**PROJECT #14036
HERBERTSON REPLAT
6/2/14**

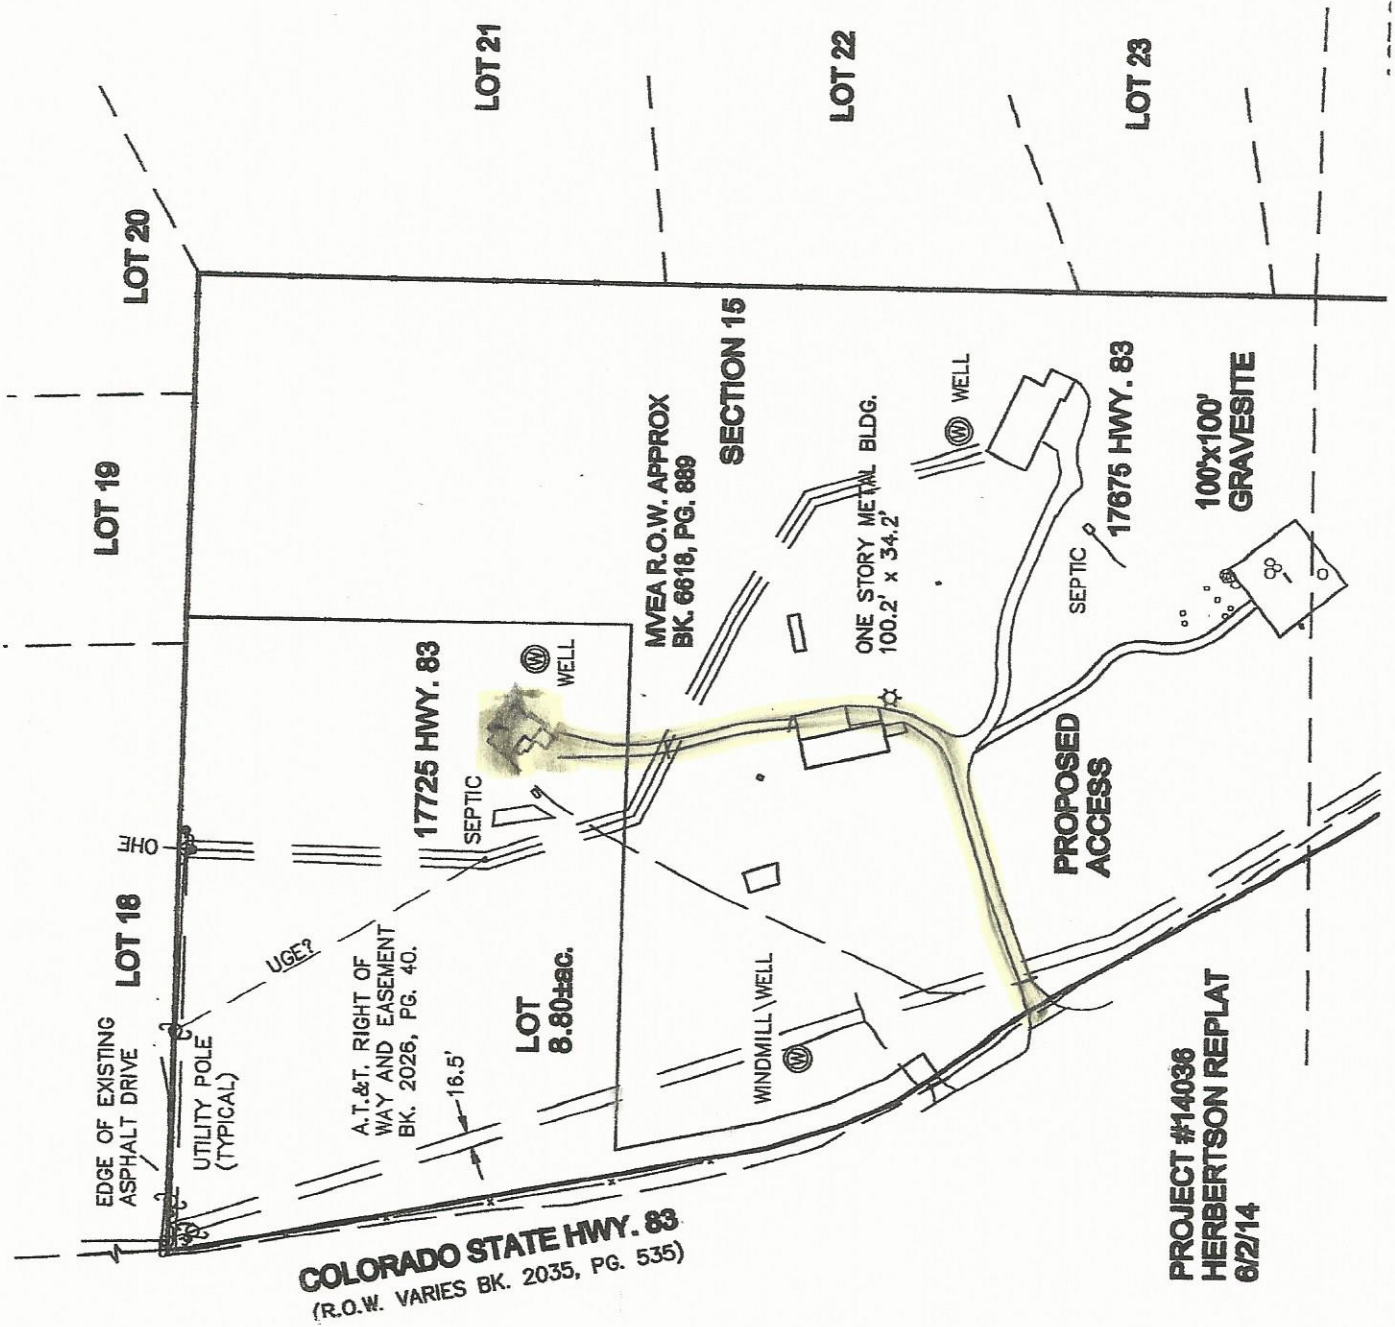
What does this line represent? Based on the assessor's it does not appear that this is a separate parcel. Revise to accurately reflect what is shown on the assessor's site.

Identify the property line

Show the distance from each structure to the closest lot line.

Identify the surface type of the driveway

Remove this information

Identify what this dashed line represents.

Add PCD File No. VA193
